**RE: 6/2020/0736/COND – Northaw House, Coopers Lane, Northaw, Potters Bar, EN6 4NG**

Thank you for consulting us on the above application for the submission of details pursuant to condition 1 (surface water drainage scheme) and 5 (arboricultural method statement) on planning permission 6/2019/0217/MAJ at Northaw House, Coopers Lane, Northaw, Potters Bar, EN6 4NG.

We advise the LPA that the information submitted in support of condition 1 in relation to surface water does not comply with the requirements of the condition. Therefore, we recommend that the LPA do not discharge condition 1.

DRAWING TITLE: PROPOSED POND SECTIONS

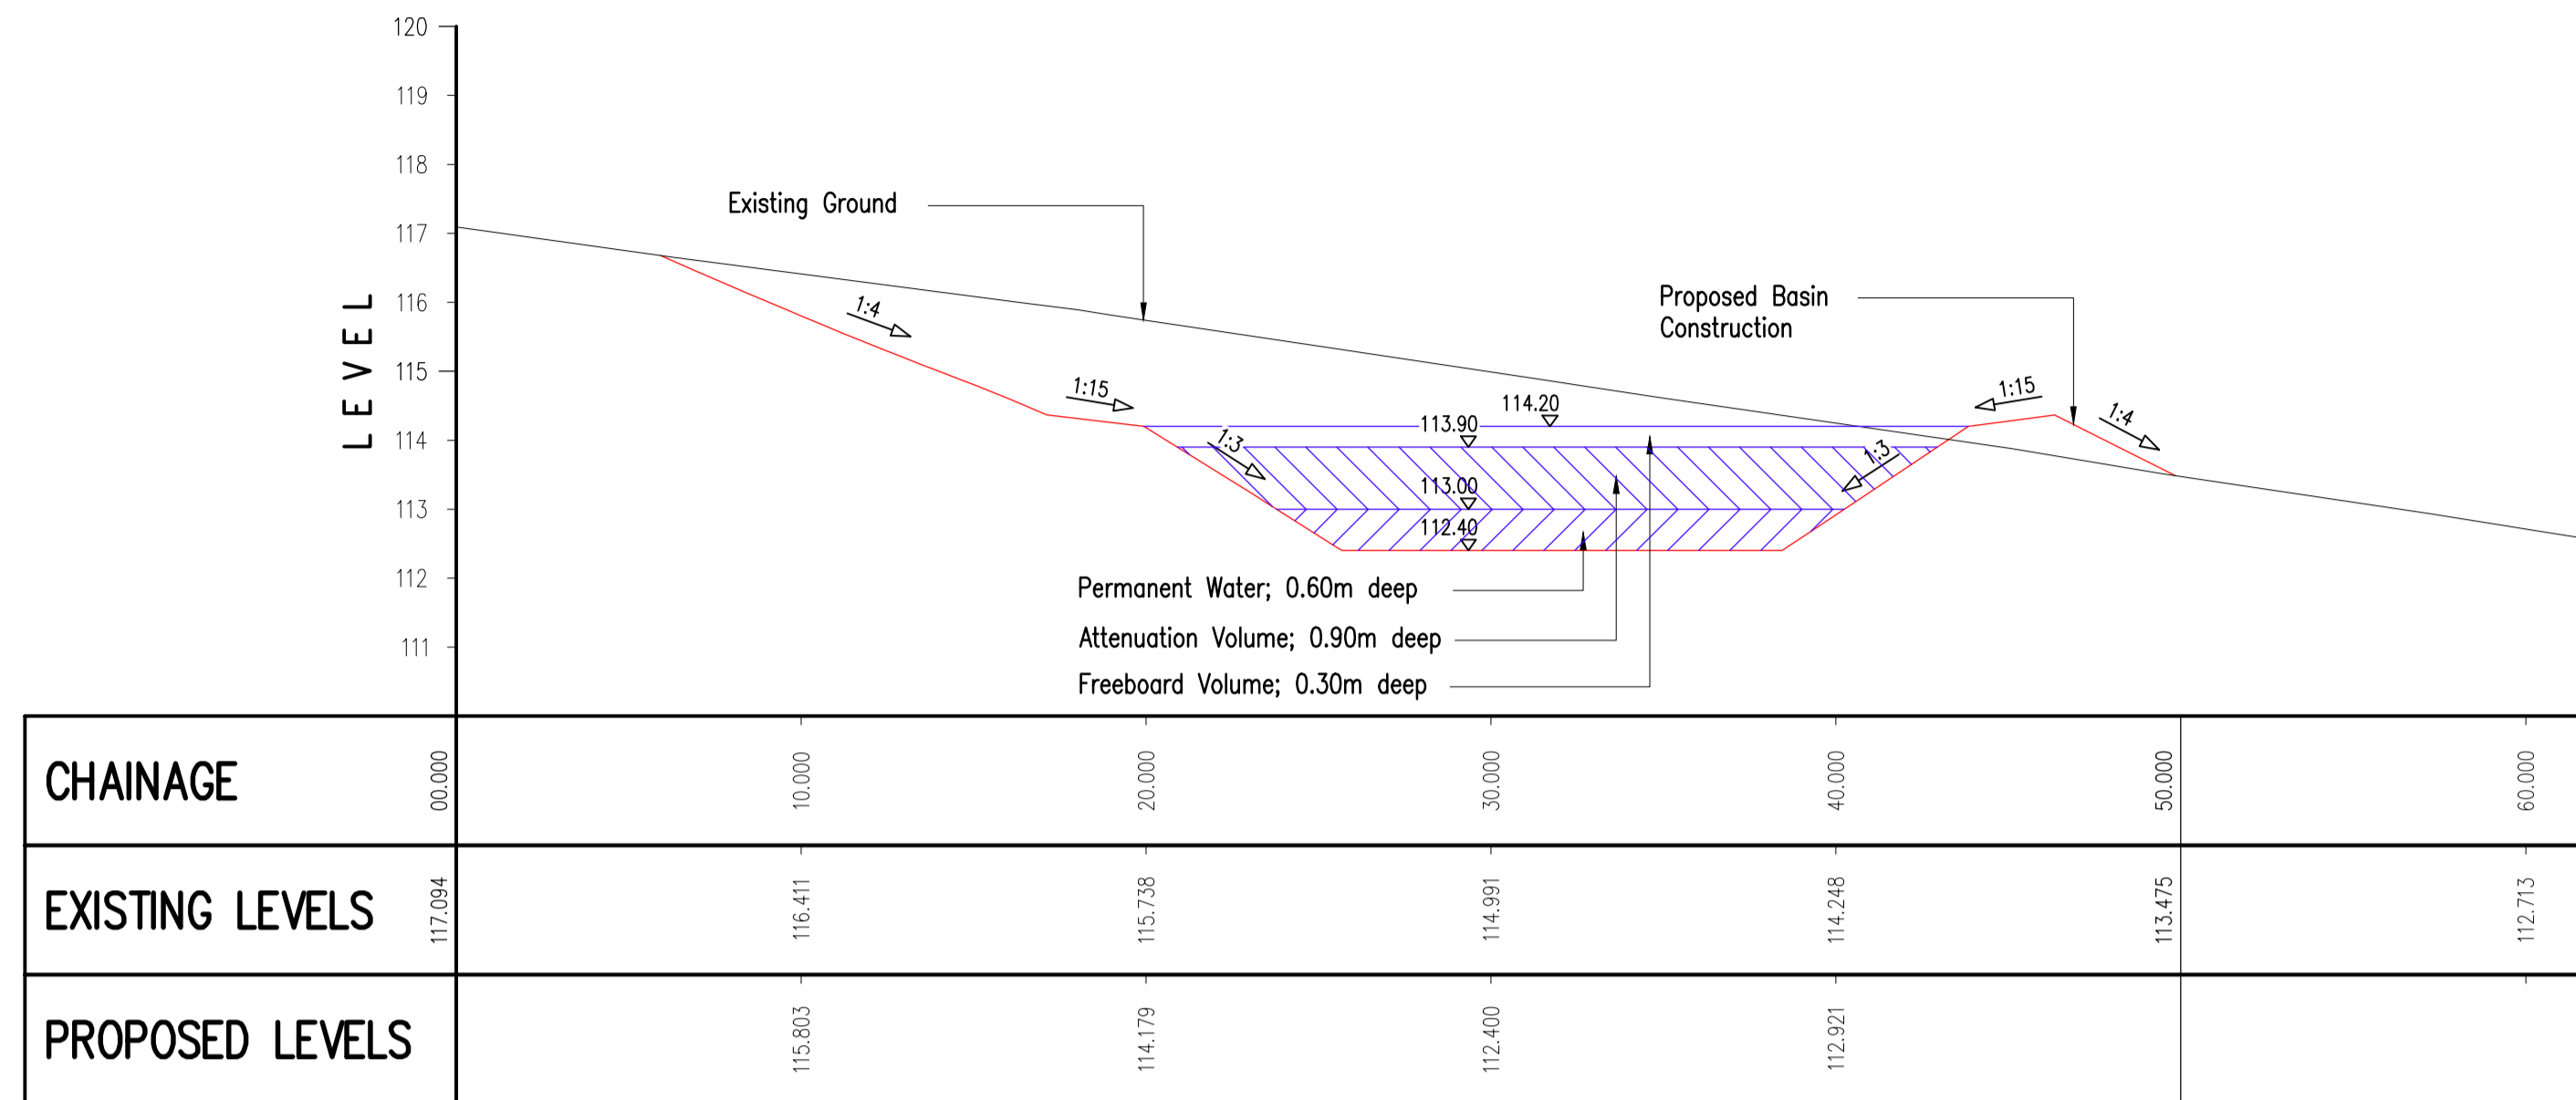
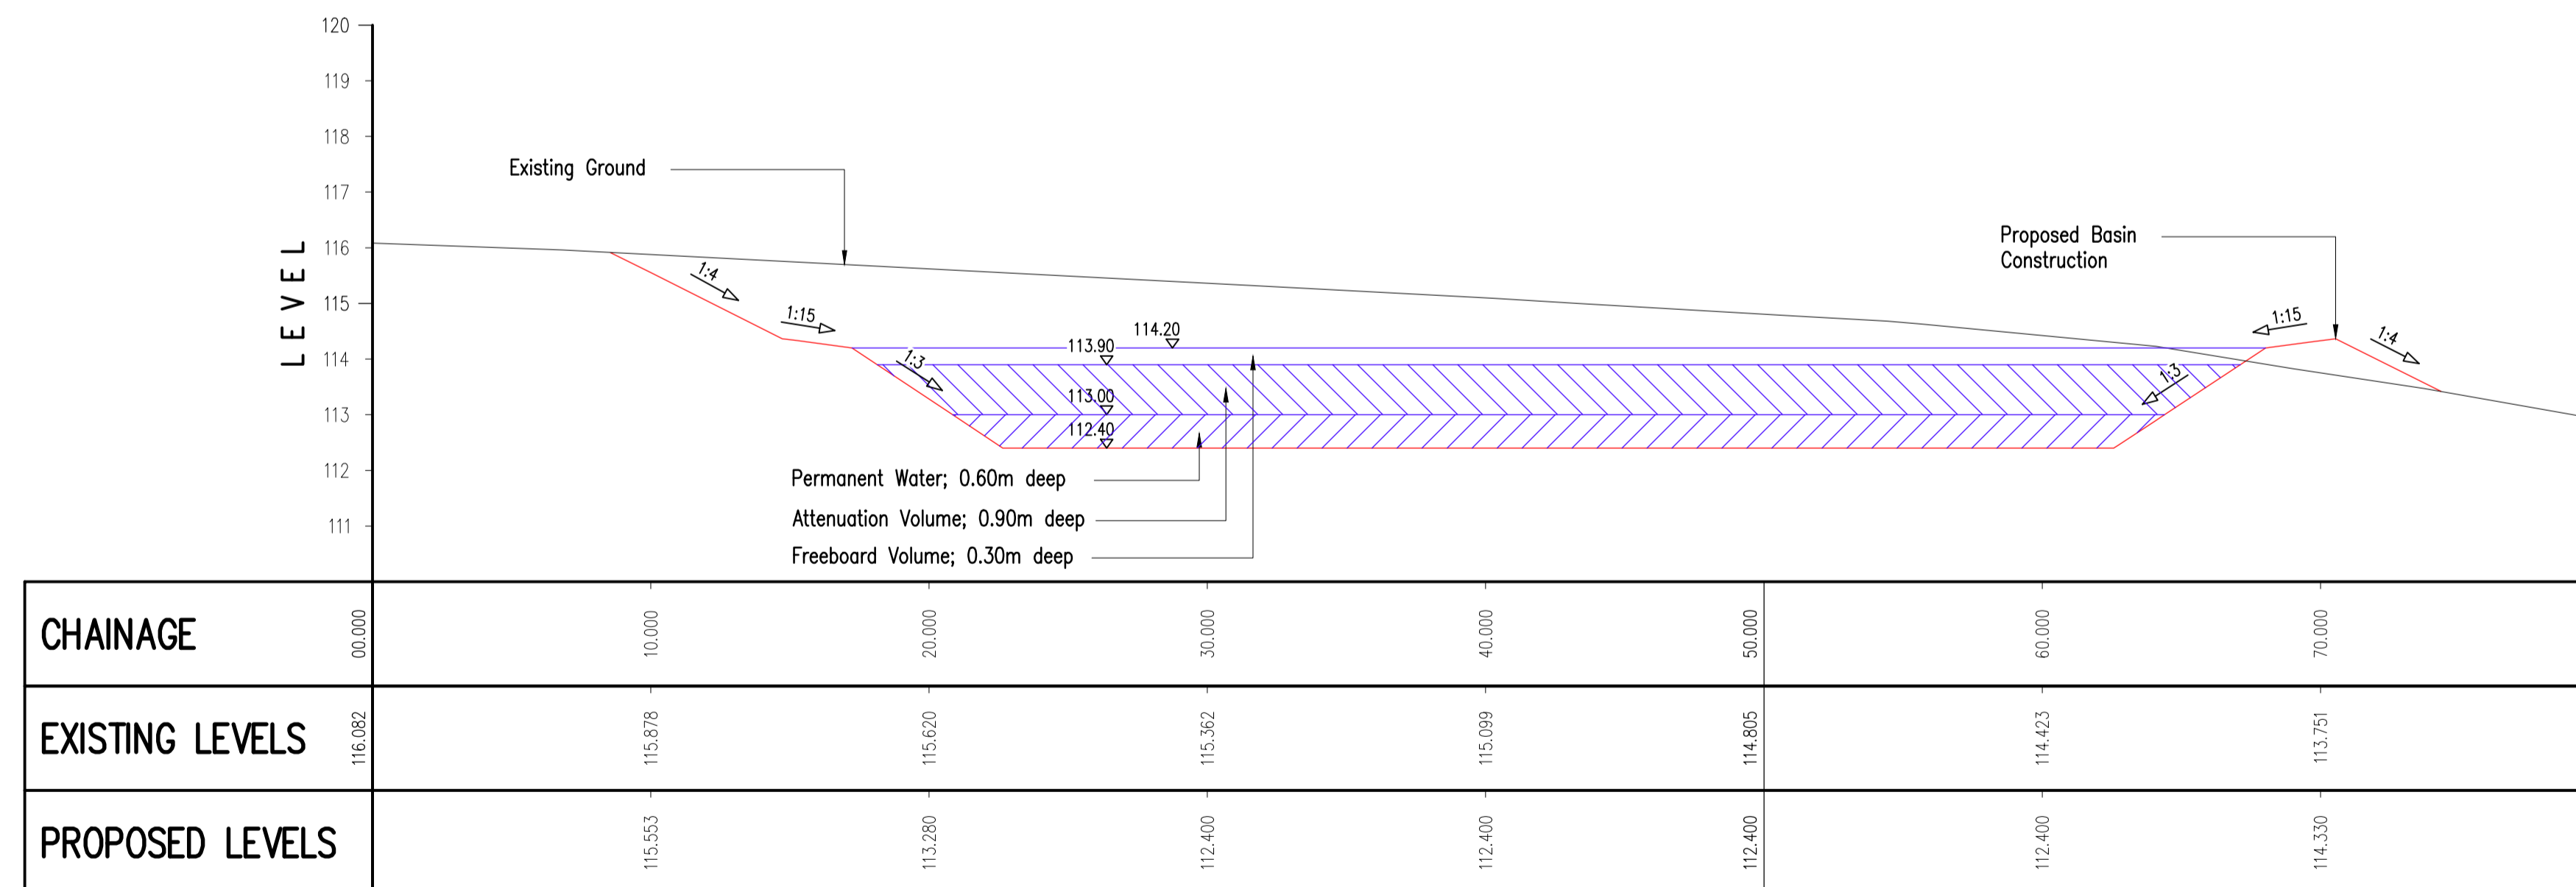
We understand that post-development calculations have been provided however lack half drain down times to the permanent water level for the pond feature.

We acknowledge the applicant has submitted the proposed drainage details drawing with indicated typical dry swale details, typical pond and other structures. We note as well, that detailed cross sections of the proposed pond have been submitted. However, inlet or outlet features have not been included.
